From: Laura Gibbons <Laura.Gibbons@arun.gov.uk>
Sent: 19 October 2021 14:23
To: Planning.Responses <Planning.Responses@arun.gov.uk>
Cc: Michael Eastham <Michael.Eastham@arun.gov.uk>
Subject: RE: Planning Consultation on: A/188/21/DOC

Application No: A/188/21/DOC

Site Address: Land at Dappers Lane Angmering Littlehampton

Description of Works: Approval of details reserved by condition imposed under ref A/76/20/PL relating to Condition Nos 17 - existing & proposed ground levels, 18 - surface water drainage, 19 - maintenance & management of surface water drainage, 21 - discharge flows to watercourses and 22 - foul drainage system

REF 20079 - CC12

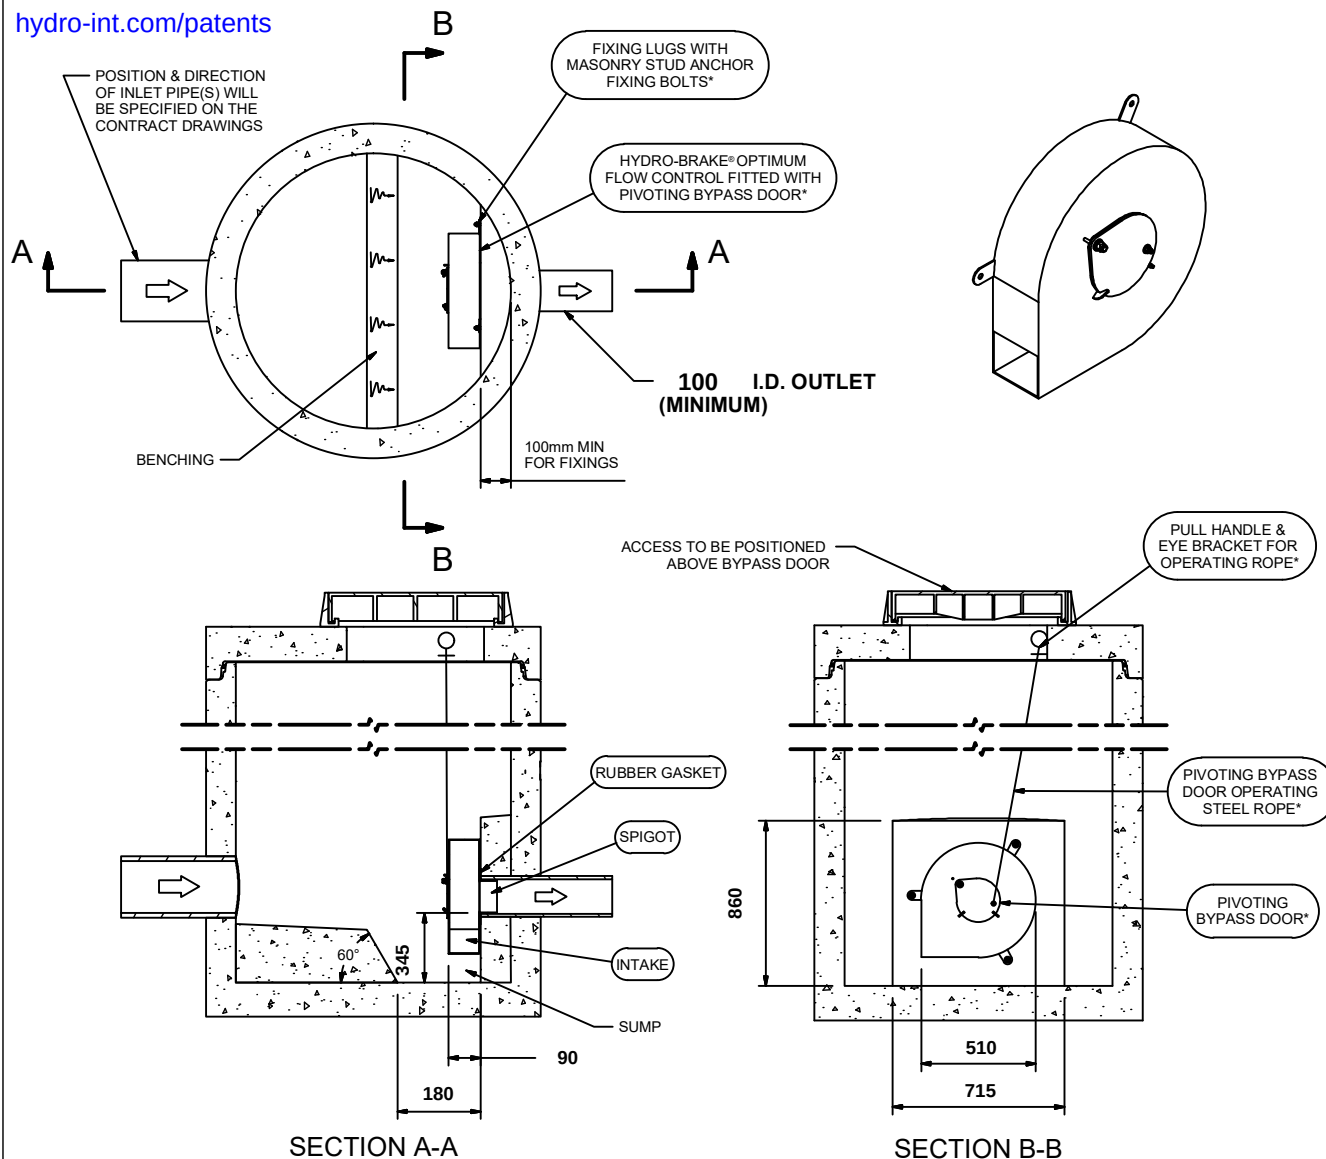
Overflow levels at CC12 and CC28 appear to be below 100 year plus 40% cc water level. — Checked, and can confirm the overflow levels are above the 100 year + 40% CC water level within the relevant Node/MH. Okay, point closed.

Client	PERSIMMON Together, we make a home
Project	Dappers Lane, Angmering West Sussex
Title	Western Ditch Improvement Works Sheet 2 of 2

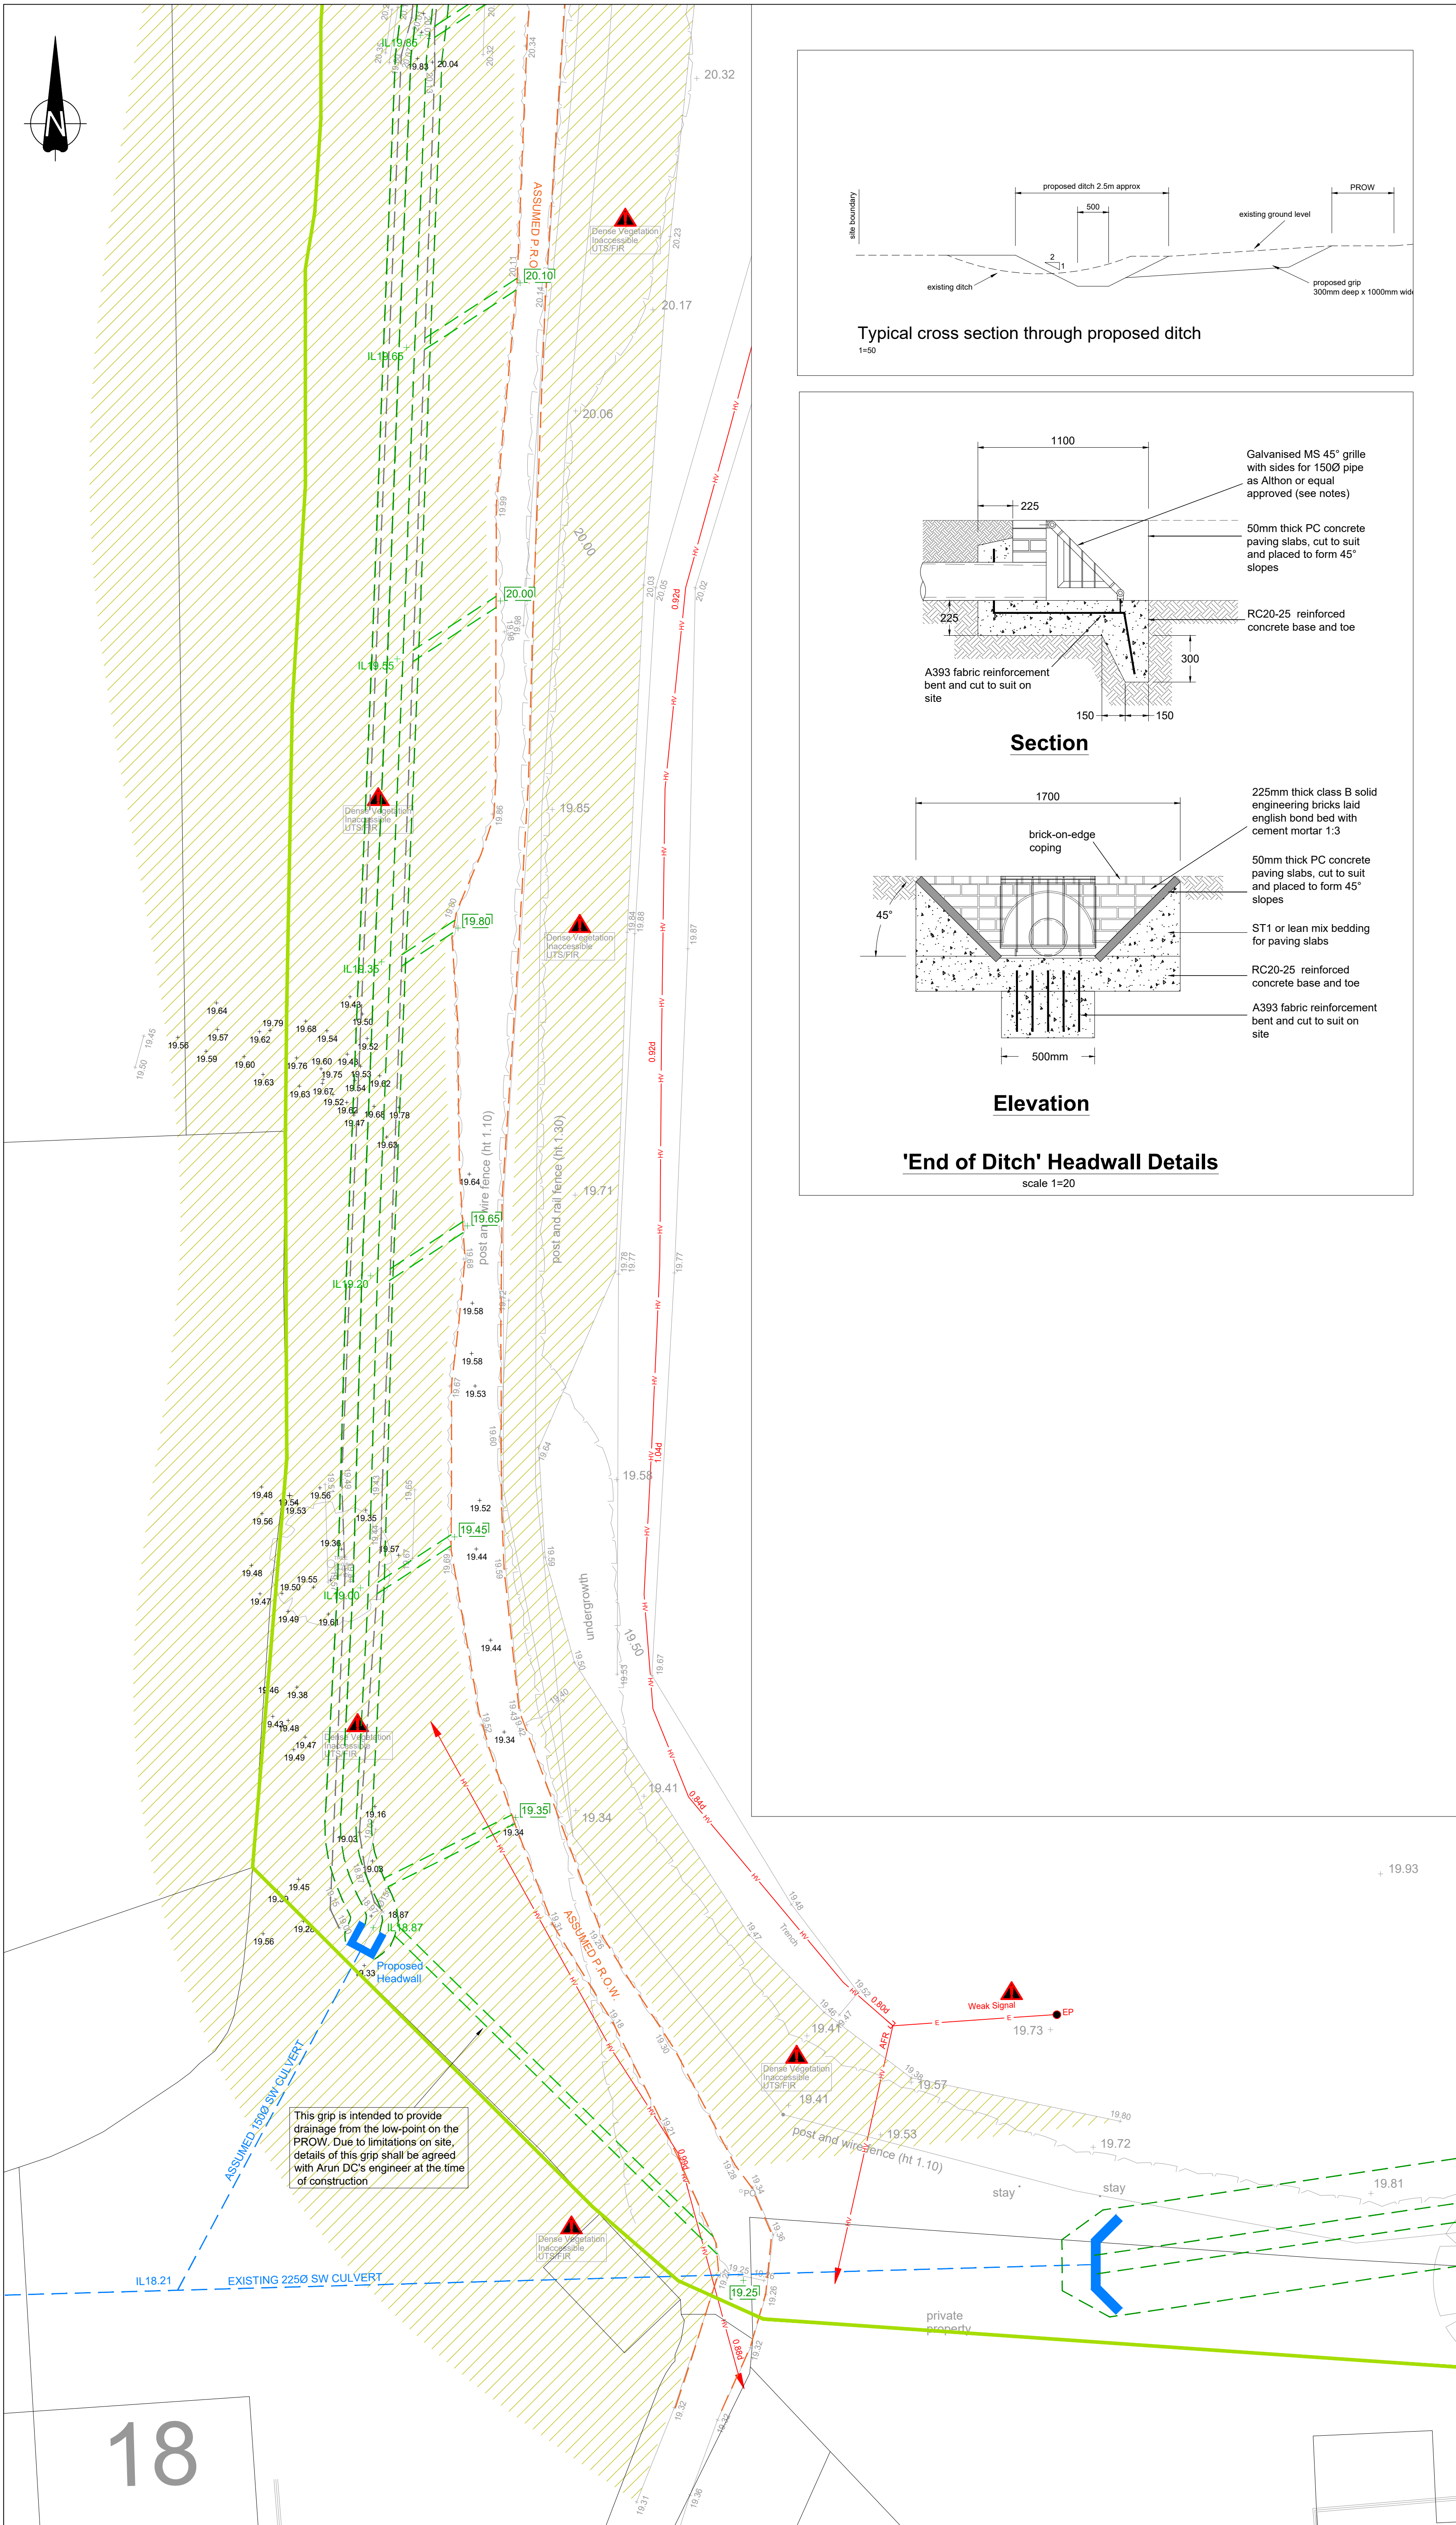
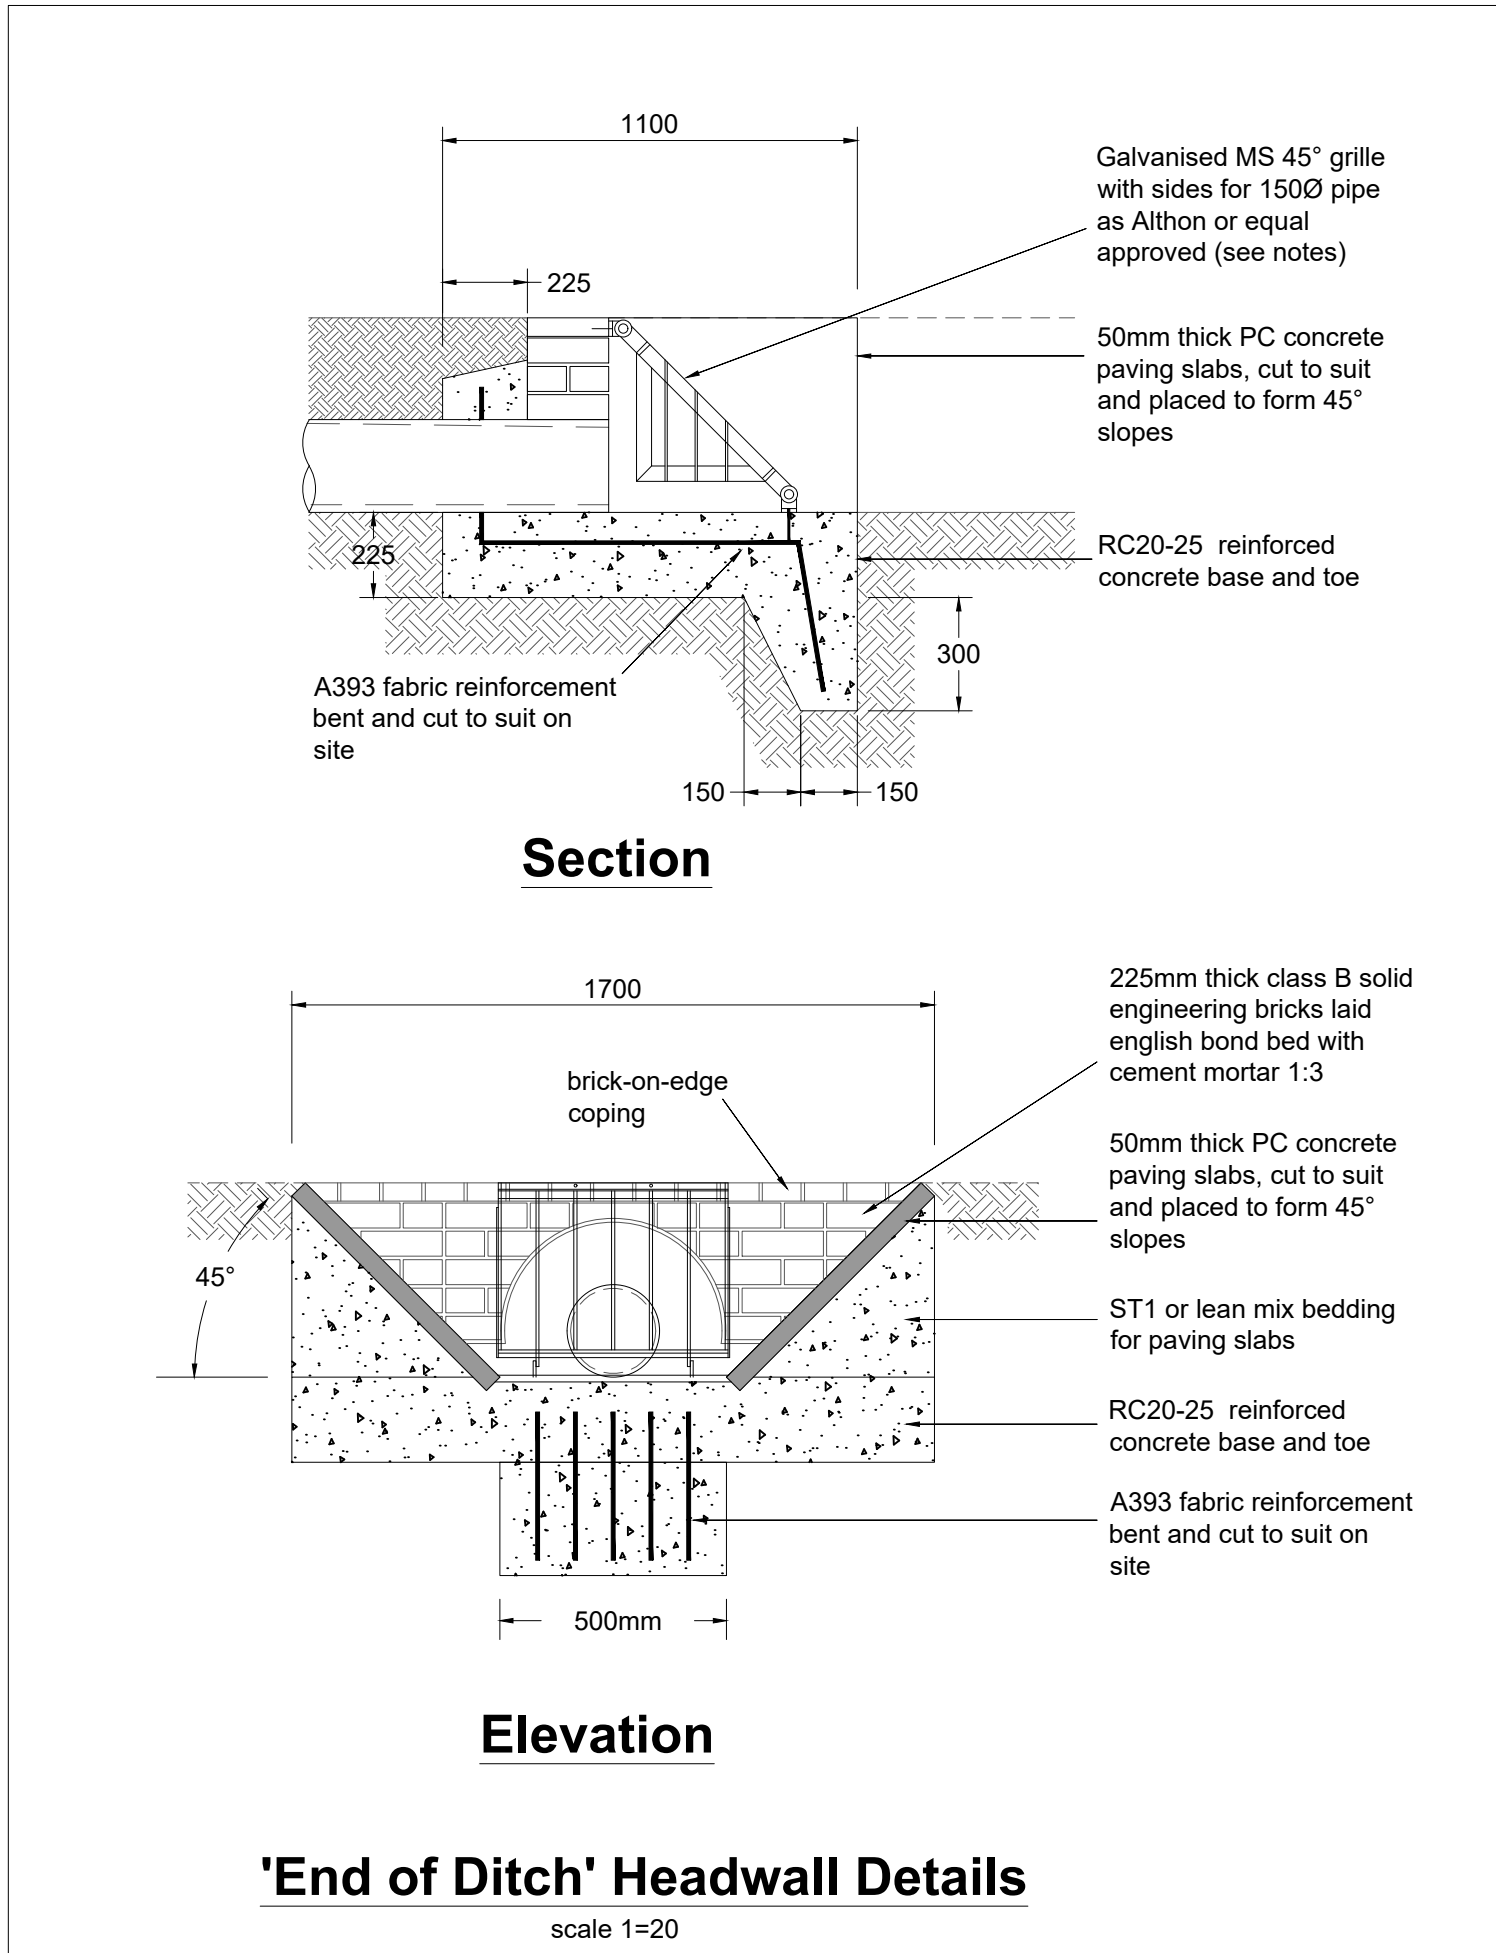
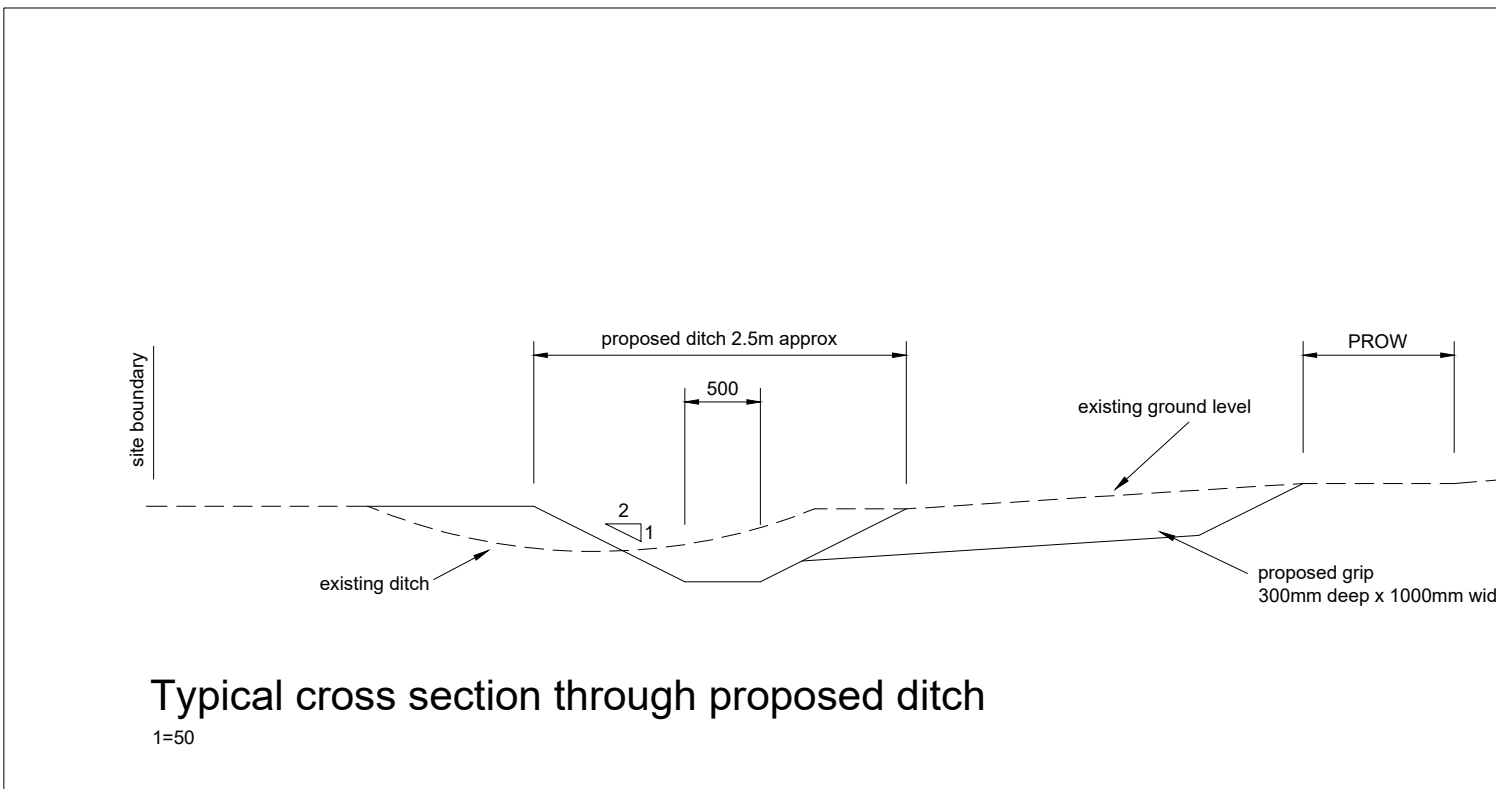
The maintenance manual should include the requirements for riparian maintenance of the watercourse, this should include detail of the monitoring, regular maintenance and occasional maintenance as well as a statement of why riparian maintenance is required. Reference should be made to a drawing showing the extents of watercourses for which the management company will have responsibility for maintaining.

Land drainage consent has not been granted to date. Furthermore, it is unclear how current proposals for the basin can be delivered without significant impact upon the ordinary watercourse. – We originally made the application on 05/08/2021, as far as we are aware, this was agreed to be sufficient to discharge this condition.

Once reviewed, please feel free to call to discuss any areas you wish. *Please supply evidence of land drainage consent.*
